ACCESSIBILITY ASSESSMENT REPORT

PROJECT:	300 Burns Bay Road Lane Cove NSW 2066
STAGE:	Development Application Phase
REFERENCE:	25099.3-Access
DATE:	18 February 2026
CLIENT:	Lane Cove Developments No.1 Pty Ltd

APPENDIX: A.1 LOWER GROUND FLOOR PLAN- BUILDING A-B

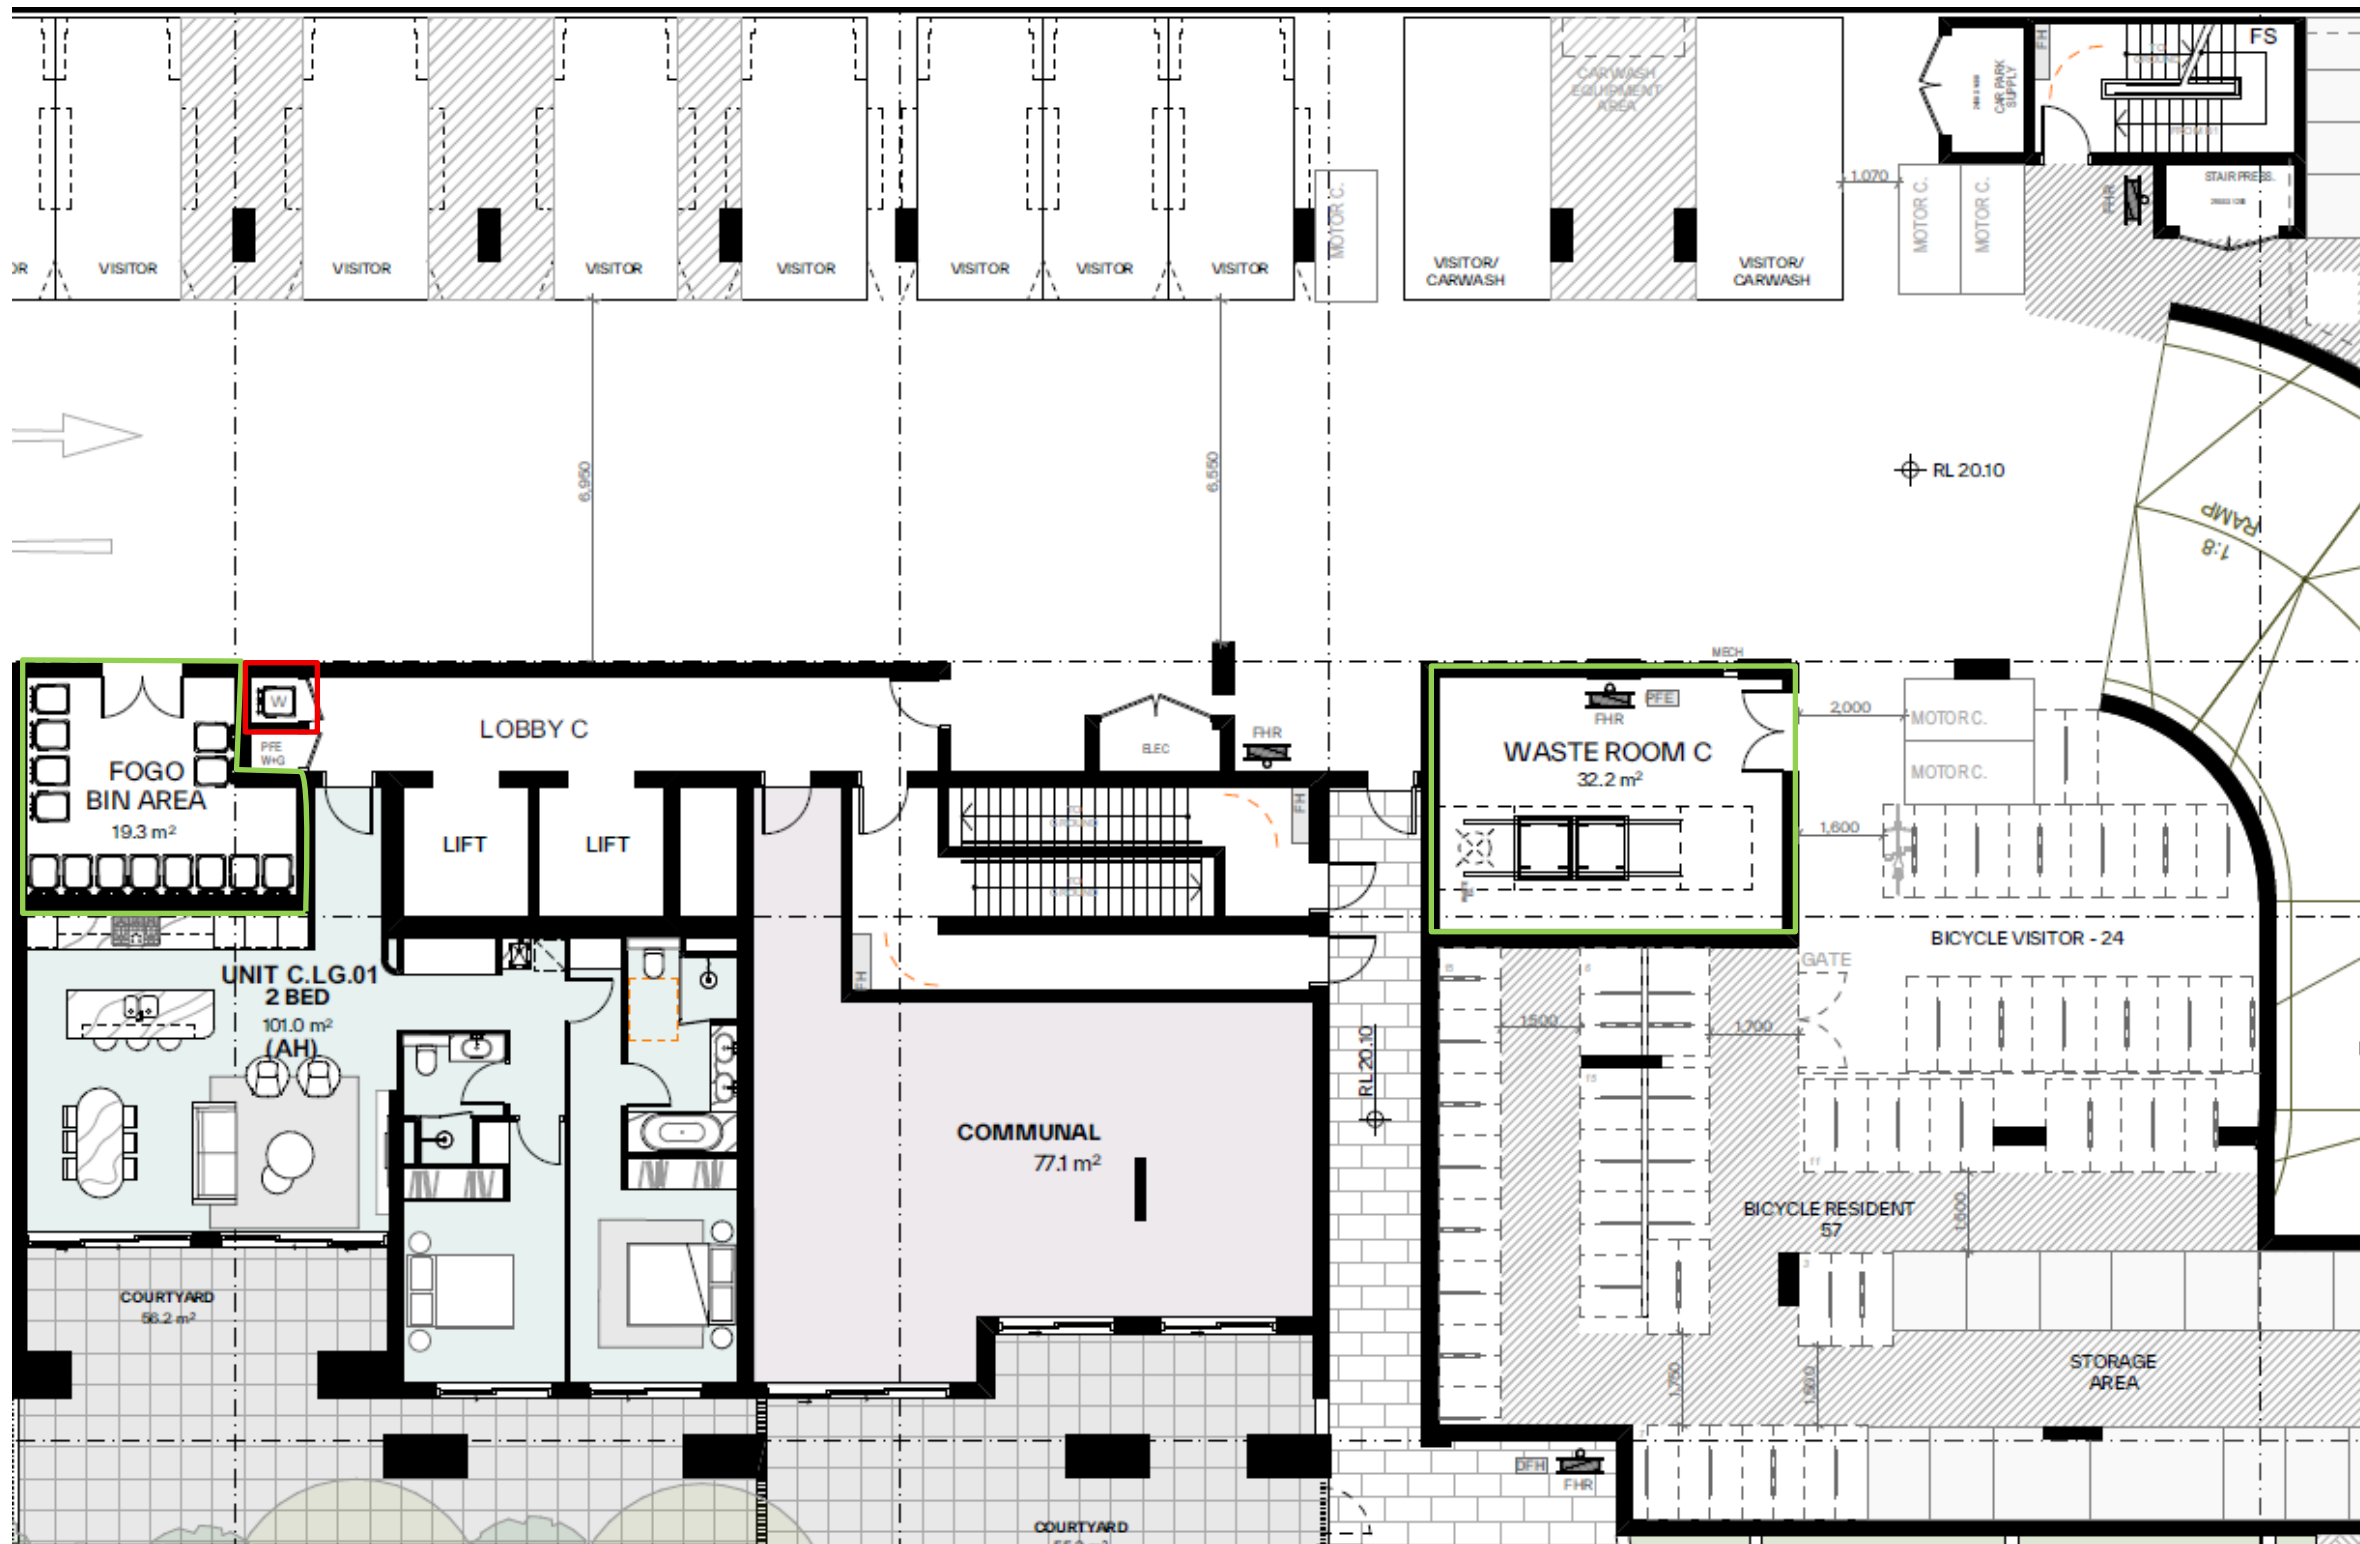
Item	DtS Clause	Issue/s	Recommendation/s for resolution
1.	D4D2	The proposed access to the park at the rear of the building has not been clearly indicated on plan, to demonstrate that the accessway is capable of complying with the requirements of AS1428.1-2021.	Further information is to be provided to demonstrate the proposed access to the park at the rear of the proposed from the communal space, is provided with step free access and capable of complying with the requirements of AS1428.1-2021.

The proposed access to the park at the rear of the building has not been clearly indicated on plan, to demonstrate that the accessway is capable of complying with the requirements of AS1428.1-2021.

Figure A 2.4 Architectural Plan – Ground Floor

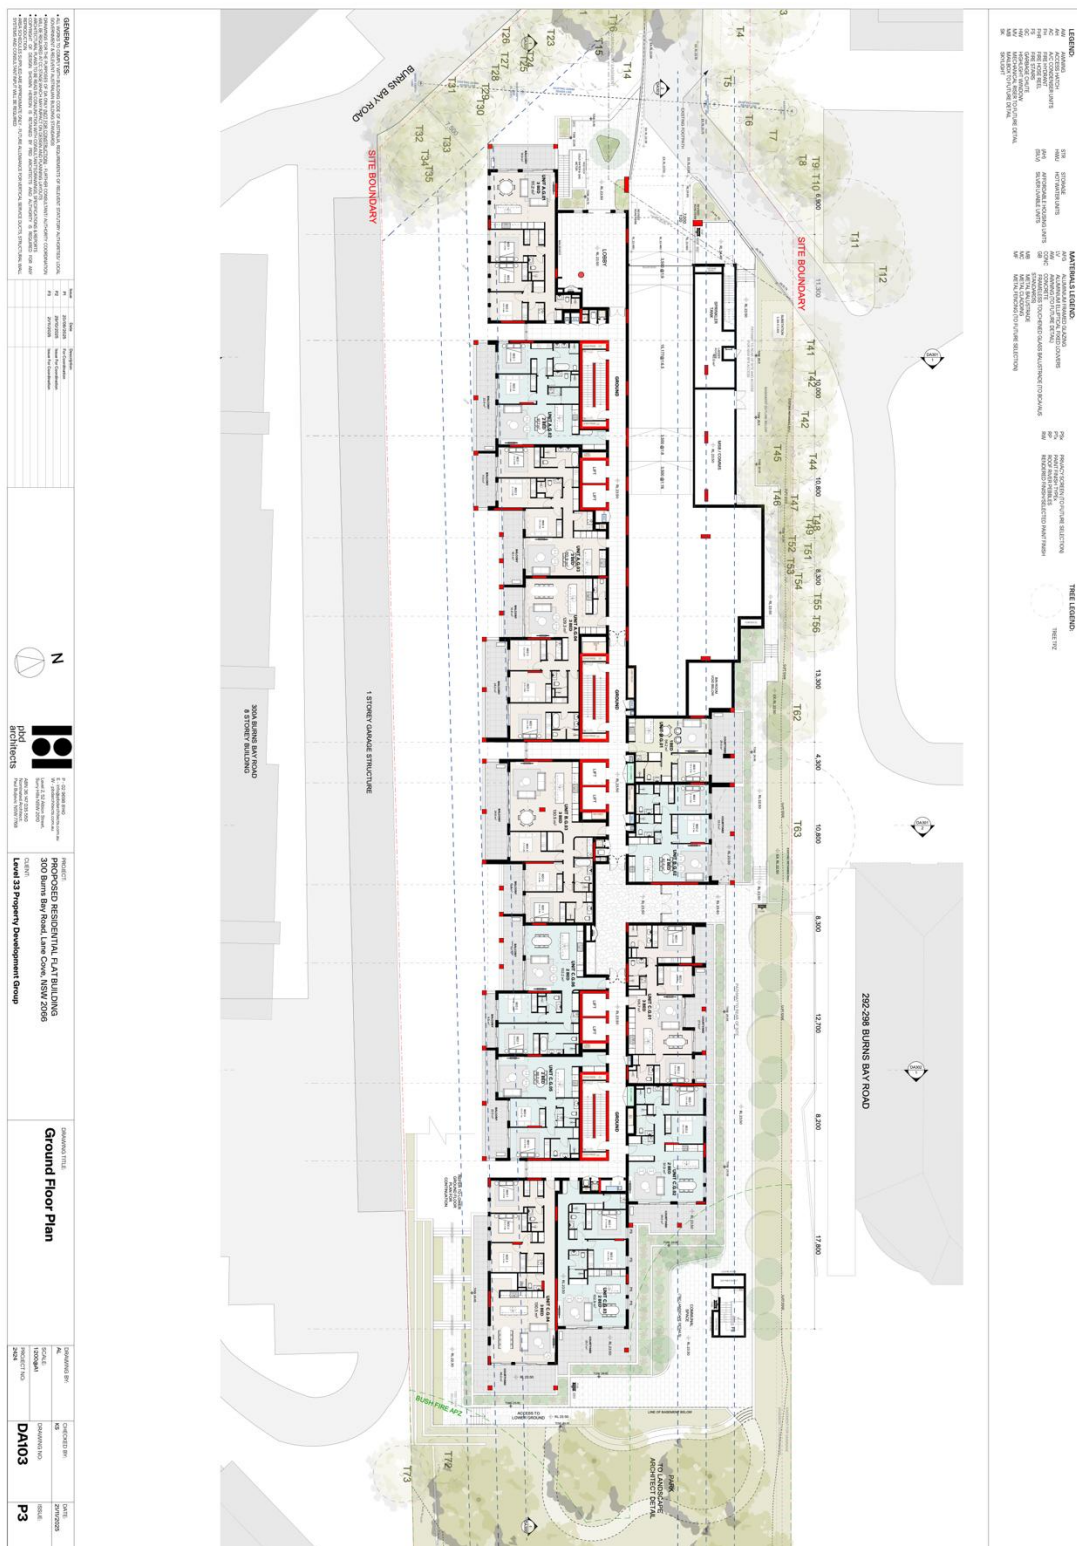
2.	D4D3	The proposed access to the building from the principal pedestrian entrance at the allotment boundary to the entry lobby on the ground floor has not been clearly indicated on plan, to demonstrate that the accessway is capable of complying with the requirements of AS1428.1-2021.	Further information is to be provided to demonstrate the accessway extending from the principal pedestrian entrance at the allotment boundary to the entry lobby on the ground floor is capable of complying with the requirements of AS1428.1-2021.

The proposed access to the building from the principal pedestrian entrance at the allotment boundary to the entry lobby on the ground floor has not been clearly indicated on plan, to demonstrate that the accessway is capable of complying with the requirements of AS1428.1-2021.
